# Comments for Planning Application SDNP/24/00421/TCA

Application Number: SDNP/24/00421/TCA

Address: 1 Albion Villas Hill Brow Road Liss Hampshire GU33 7LA

Proposal: I would like to cut down/fell two large conifer trees (T1 and T2) in my garden which are blocking out a considerable amount of light and shedding needles onto the paved area. These trees are tall and block the sunlight from a large area of the garden. T1 is extremely close to the property boundary and is touching the structure of the neighbouring parish council offices (photographs provided). I would also like to reduce the crown of a third tree which I believe is a Vibernum (T3). The branches of T3 are overhanging a large area of the garden blocking the light from plant beds. Some of the branches of T3 are overhanging my property boundary and are either touching or very close to Liss Parish Hall which is next door to my property. I would like to cut back these branches and reduce the crown of T3. I have contacted three arborists to take a look at the work who have all advised on the works. I will select a company as soon as I have received notice from this planning portal, and select a reputable company based on pr

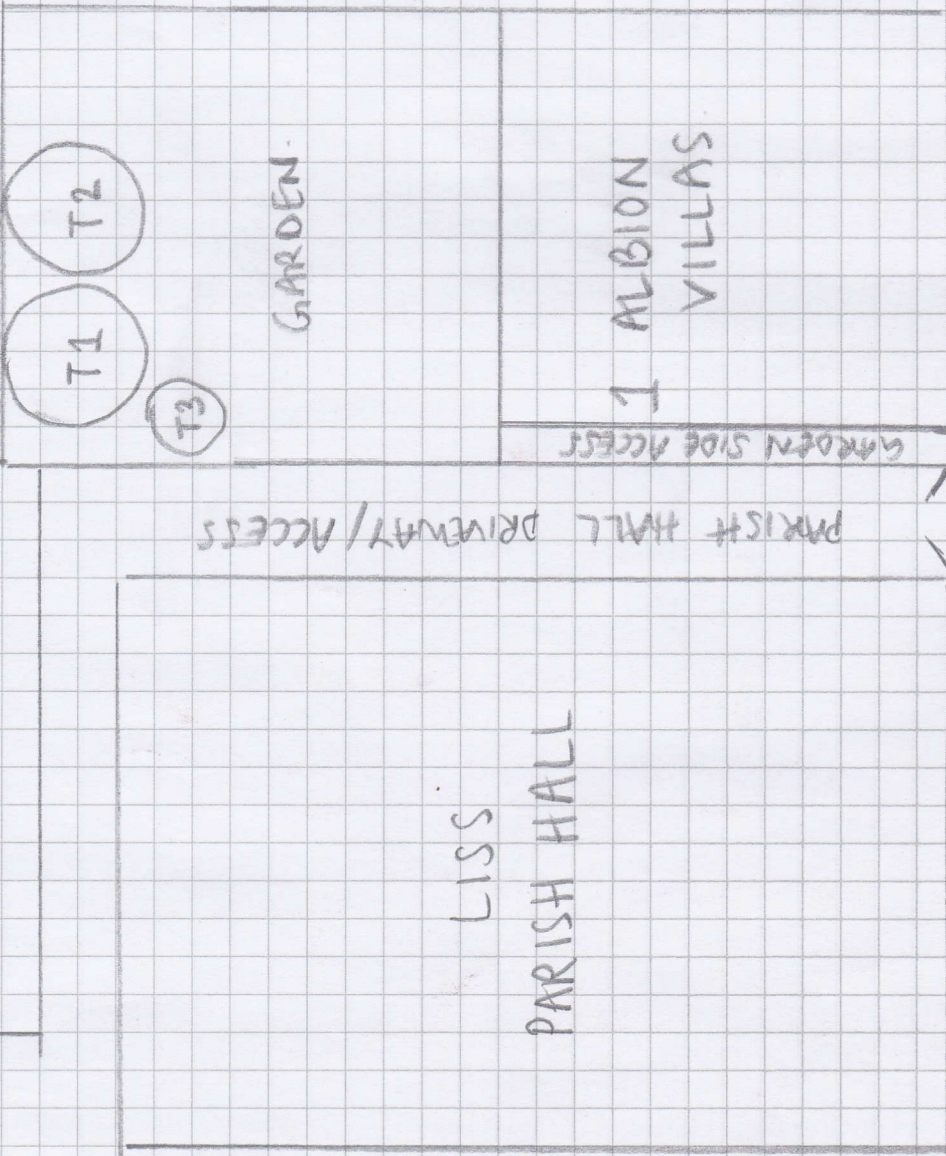
Trees T1 and T2 are on the garden boundary that faces almost directly due east. Therefore the shading effect of these trees should be much less severe than the height may suggest.

The fall of pines tends to be very localised to around the base of the trees.

I think that sympathetic pruning of tree T3 would be more appropriate than a straight crown reduction.
